# CITY OF ALBUQUERQUE

RE: **Lot 12 Block 9 Unit 18 Volcano Cliffs SAD 228**  
**6520 Papagayo NW**  
**Grading and Drainage Plan**  
**Engineers Stamp Date 4/17/17 (D10D003I12)**

ENGINEER'S SEAL  4/21/17	LOT 12 BLOCK 9 VOLCANO CLIFFS UNIT 18	DRAWN BY JDG
	GRADING AND DRAINAGE PLAN	DATE 04-17-2017
DAVID SOULE P.E. #14522	 <i>Rio Grande Engineering</i> 1606 CENTRAL AVENUE SE SUITE 201 ALBUQUERQUE, NM 87106 (505) 872-0999	SHEET # 1 OF 1
		JOB #

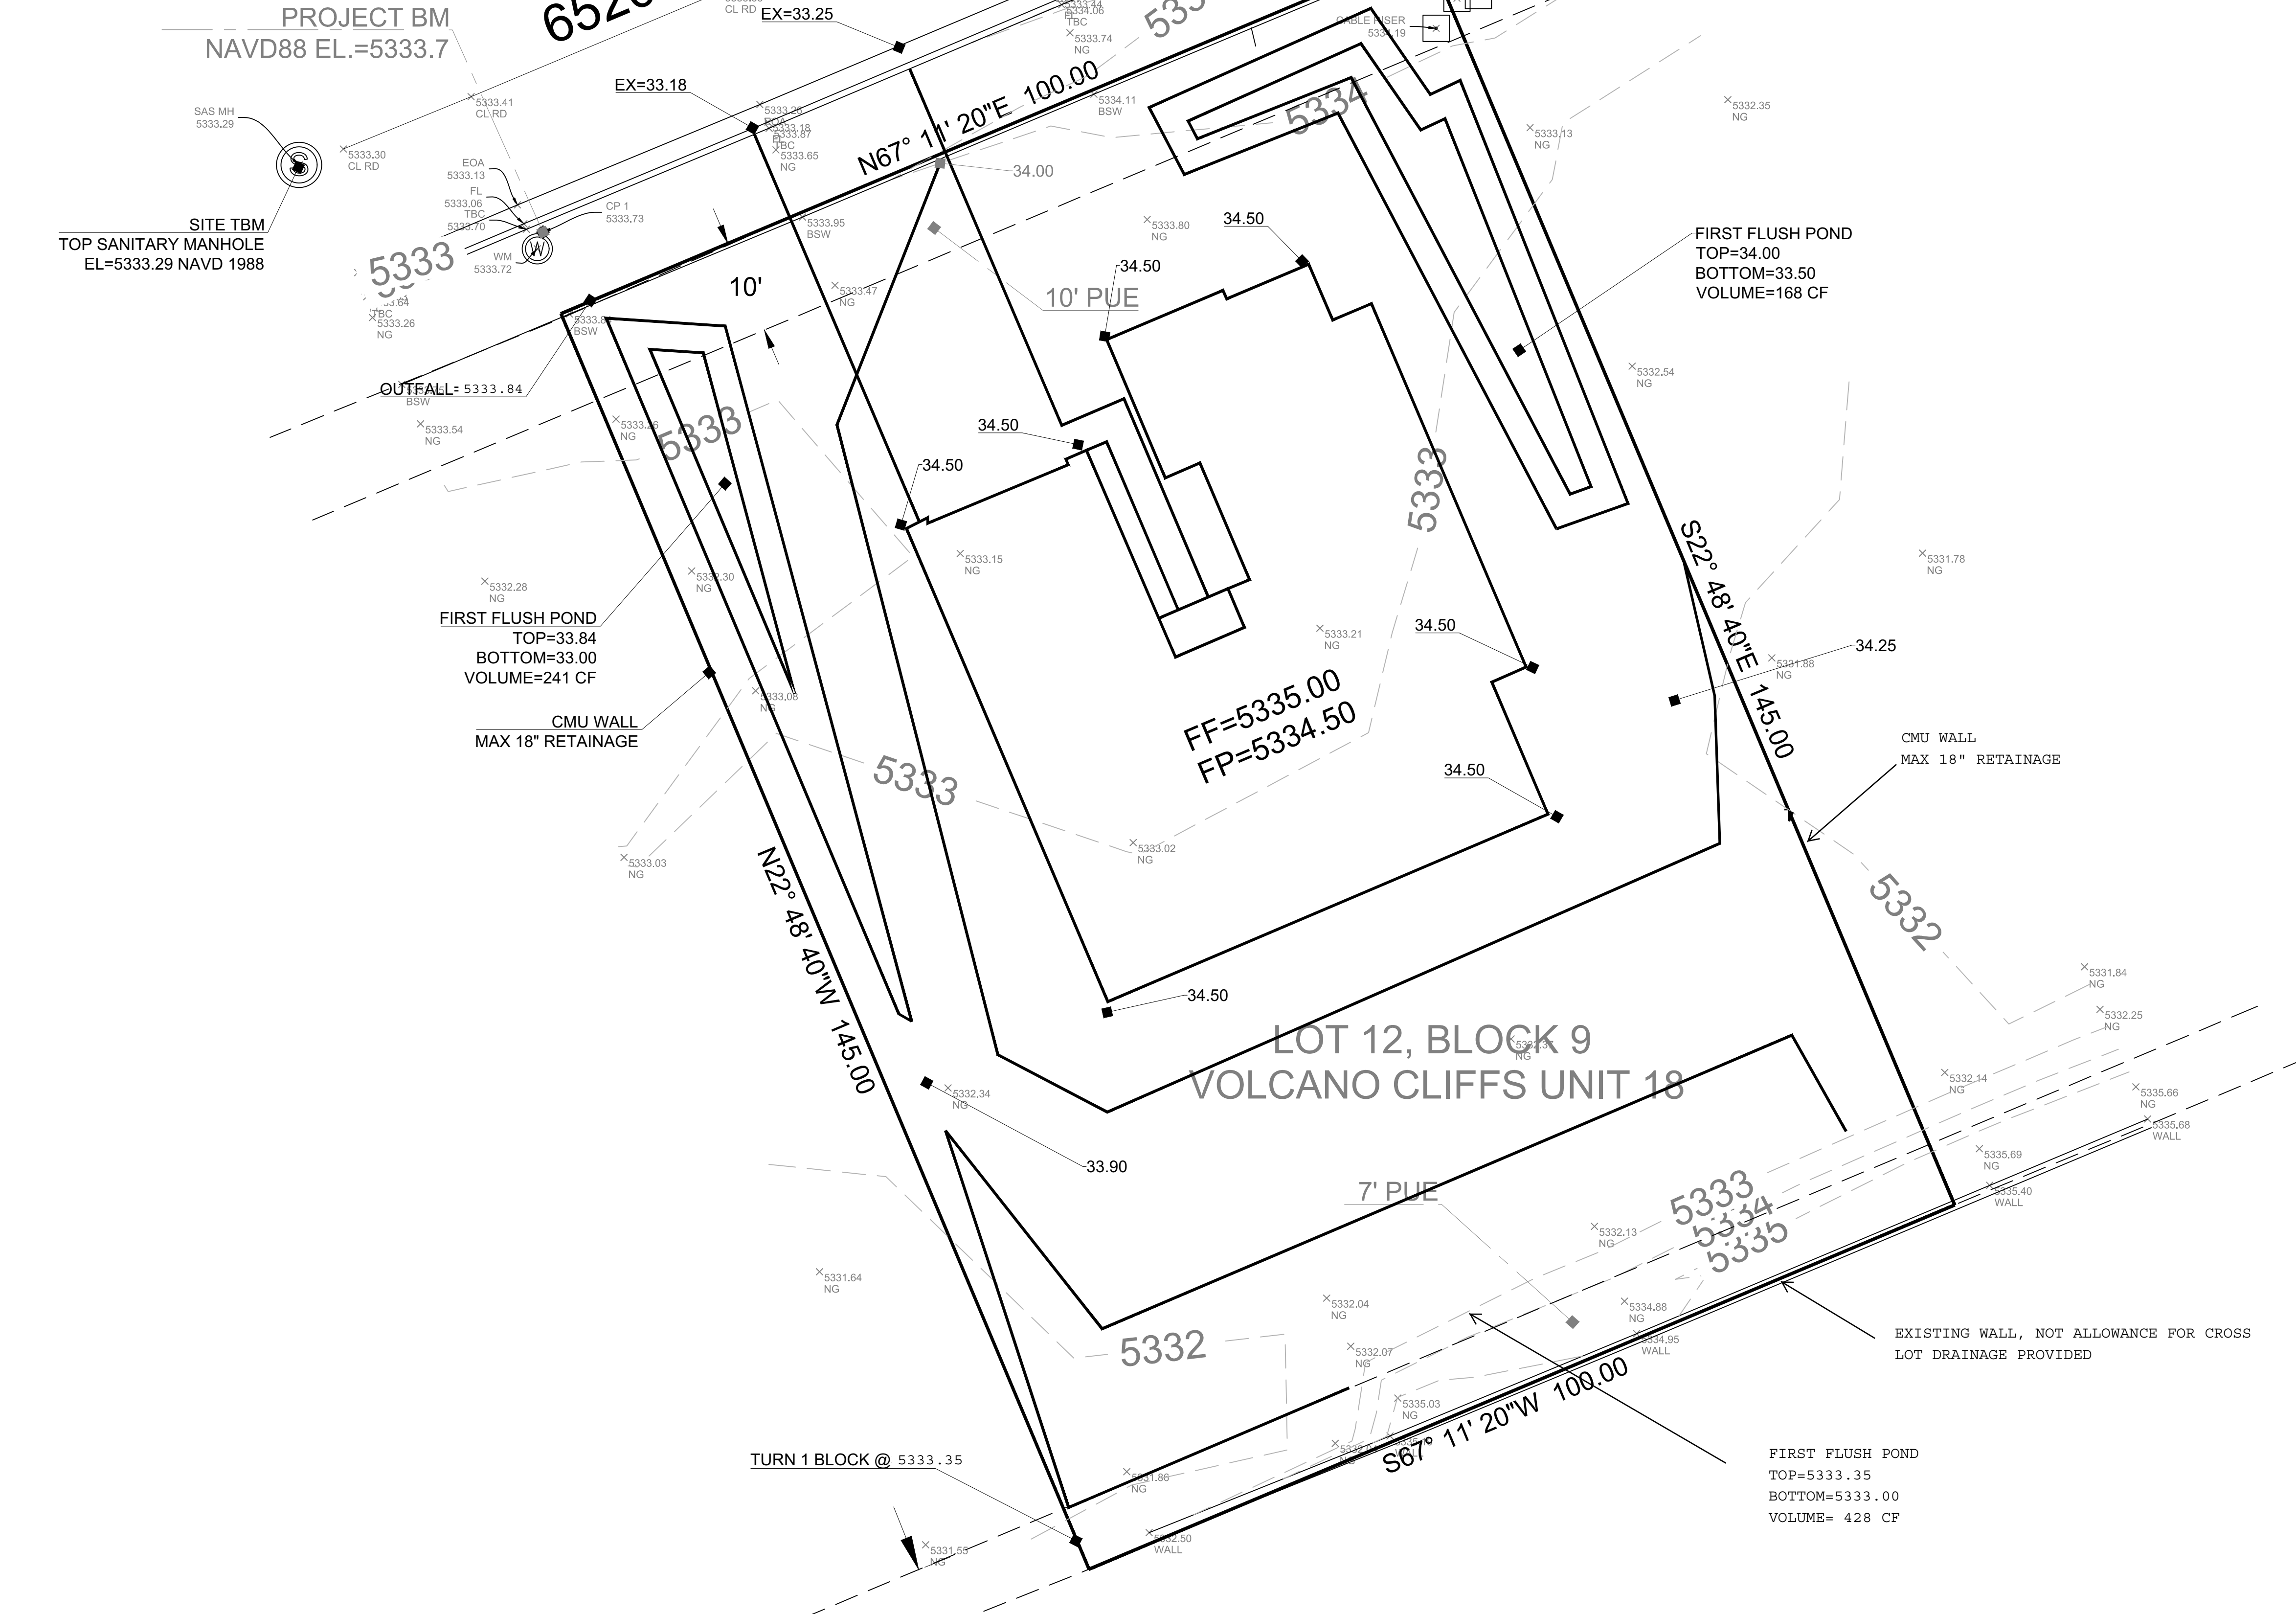
- Provide an opening in Garden Wall at the SW corner.
- Provide the water quality ponds in the rear yard where cross lot flow is to be provided. Flows do not need to leave front yard.
- Provide calculations for the openings in the walls.
